CITY OF ALBUQUERQUE

Re: Loves Building Expansion
2200 6th St. NW
30-Day Temporary Certificate of Occupancy
Transportation Development Final Inspection
Engineer's Stamp dated 10-22-24 (H14-D025)
Certification dated 08-08-2025
TRANS-2025-00218

**RE: APPROVED SITE TRAFFIC CIRCULATION LAYOUT
REQUEST FOR PERMANENT CERTIFICATE OF OCCUPANCY
LOVE'S ALBUQUERQUE NEW MEXICO
2200 6TH ST. NW, ALBUQUERQUE, NM 87102**

ENGINEER'S SEAL	LOVE'S ALBUQUERQUE, NM	DRAWN BY pm
		TRAFFIC CIRCULATION LAYOUT	DATE 10/22/24
		 5571 MIDWAY PARK PL NE ALBUQUERQUE, NEW MEXICO 87109 (505) 858-3100 www.tierrawestllc.com	SHEET # TCL-1
RONALD R. BOHANNAN P.E. #7868			JOB # 2024072

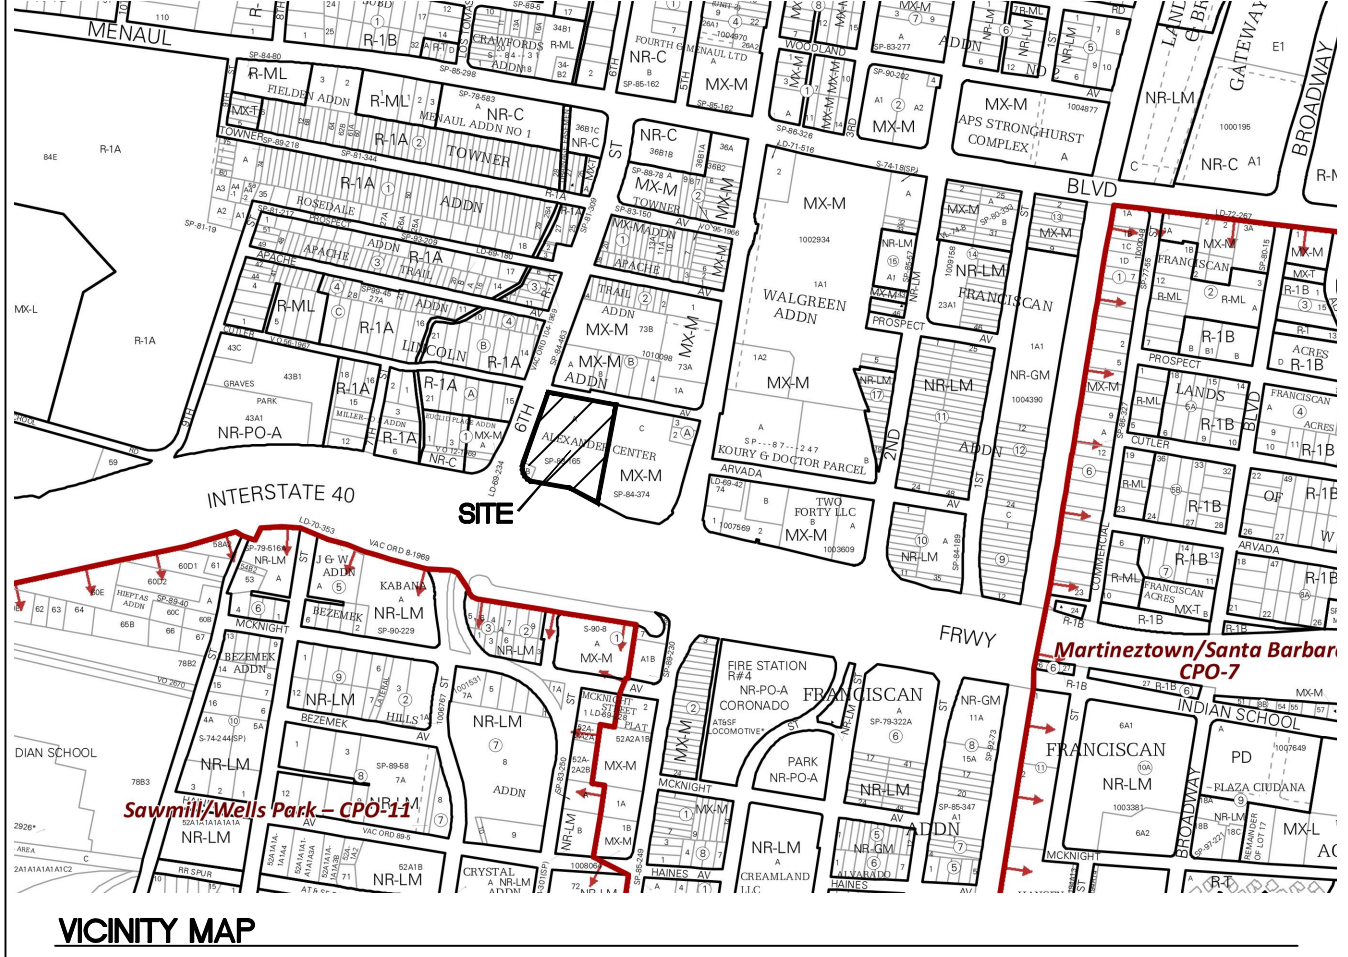
- Per ADA city requirements, the pathway around any obstacle on the sidewalk (off Cutler Ave.) must be minimum 4 ft. However, per site visit the distance between the power pole and the bollard was 33 in. Please adjust the layout to meet the city standard.

- Per the City requirements, "All broken or cracked sidewalk must be replaced with sidewalk and curb & gutter."

- Per approved site plan, please provide an ADA ramp. The existing ramp does not meet ADA city standard.
- The ADA access aisles shall have the words "**NO PARKING**" in capital letters, each of which shall be at least one foot high and at least two inches wide, placed at the rear of the parking space so as to be close to where an adjacent vehicle's rear tire would be placed. (66-1-4.1.B NMSA 1978)
